Ref: AW/296/17/HH

We being the owners of 27 Willowhale Avenue object to the above planning application

AW/296/17/HH on the following issues:-

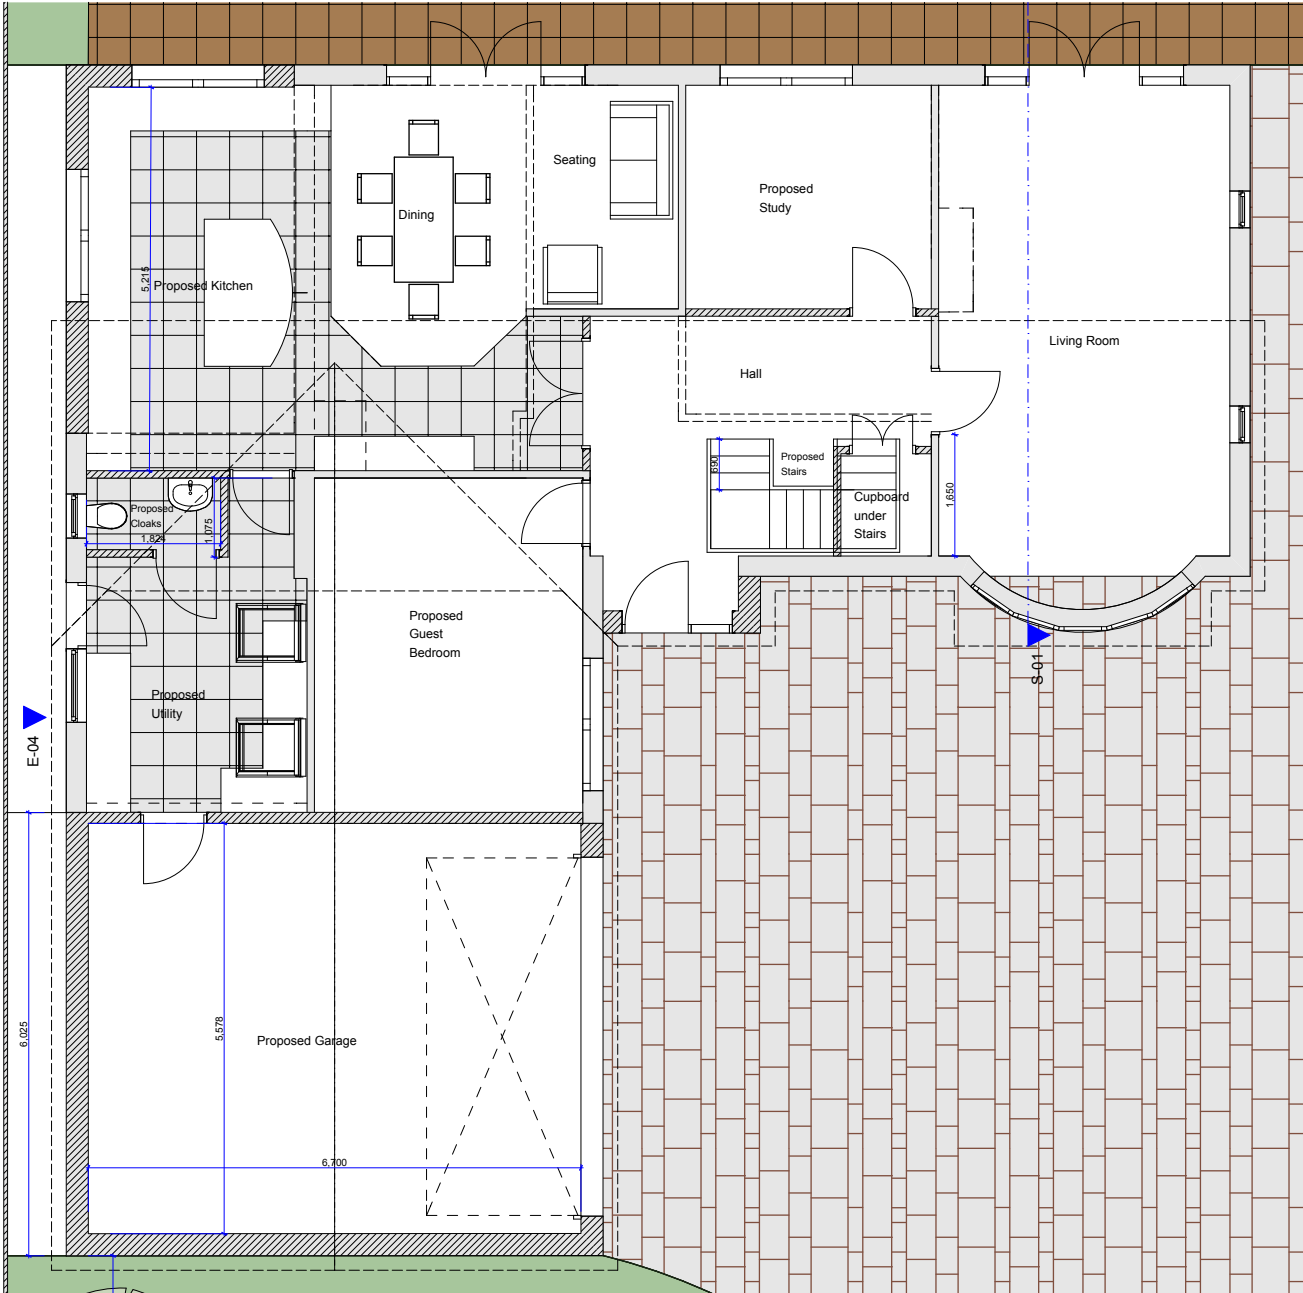
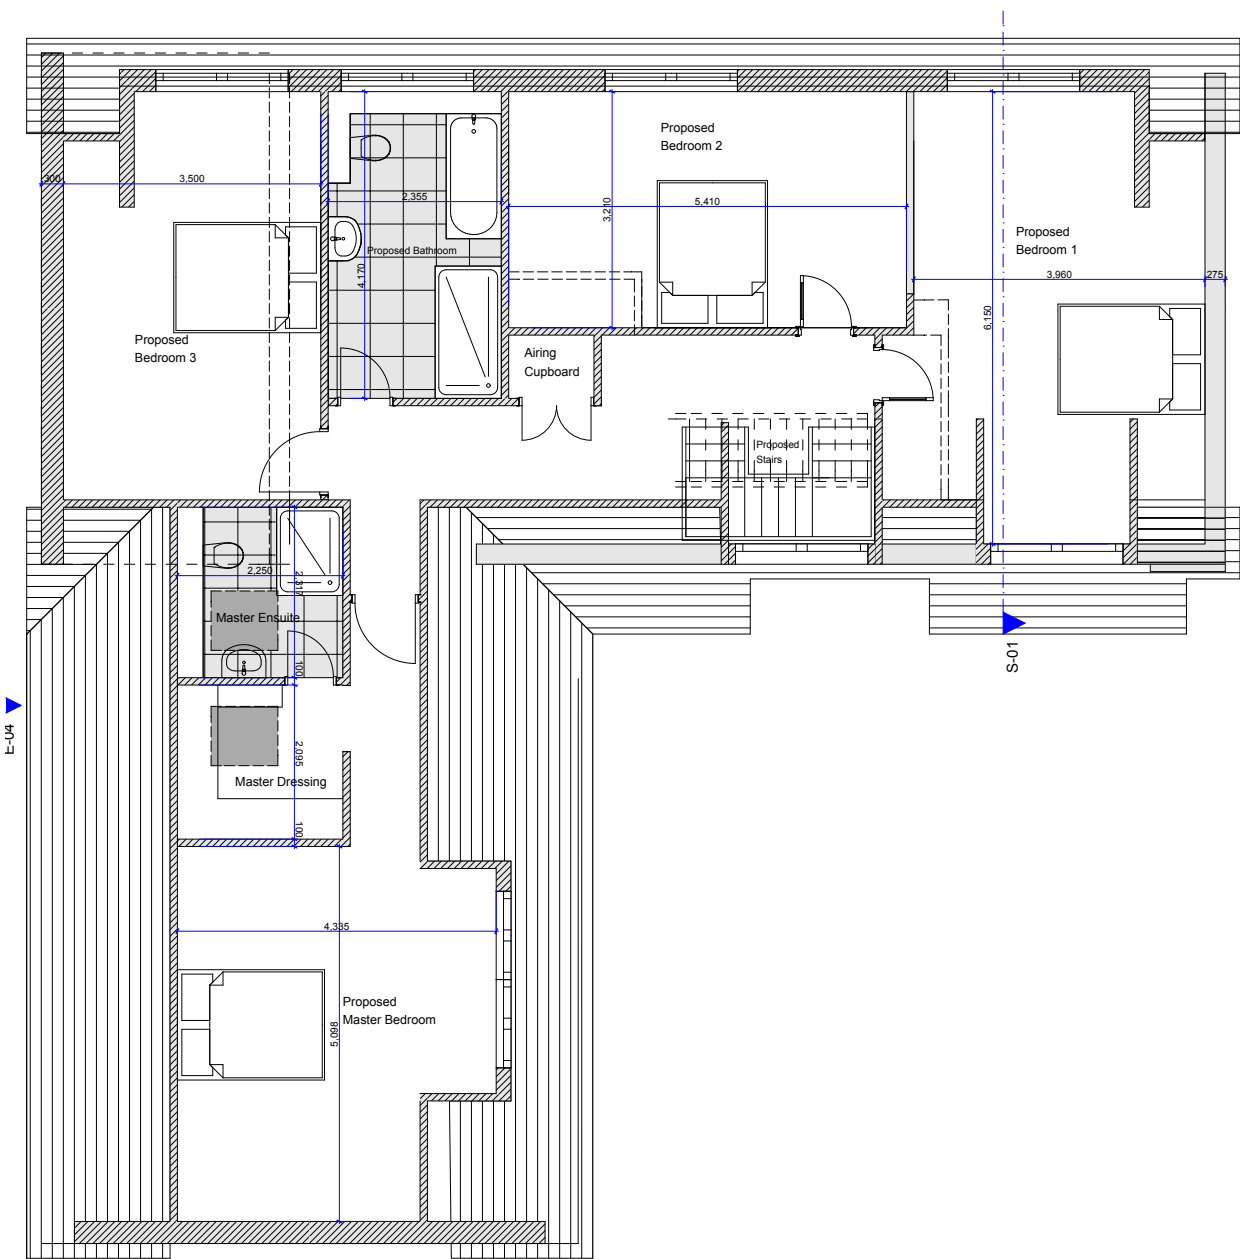
1. The 2 storey extension to the front of the property projects out to far approximately 5.70 metre from existing garage which already projects 3.10metre front building line and will block out the light to my front lounge room.
2. The side extension will also restrict the light to my south facing bedroom as well as my conservatory.
3. The rear facing dormer is too large and contains 4 dormer windows and runs the whole length of the back of the roof.
4. Generally the whole scheme is too large with 4 dormers on the front of the building and not in keeping with the other properties in Willowhale Avenue.
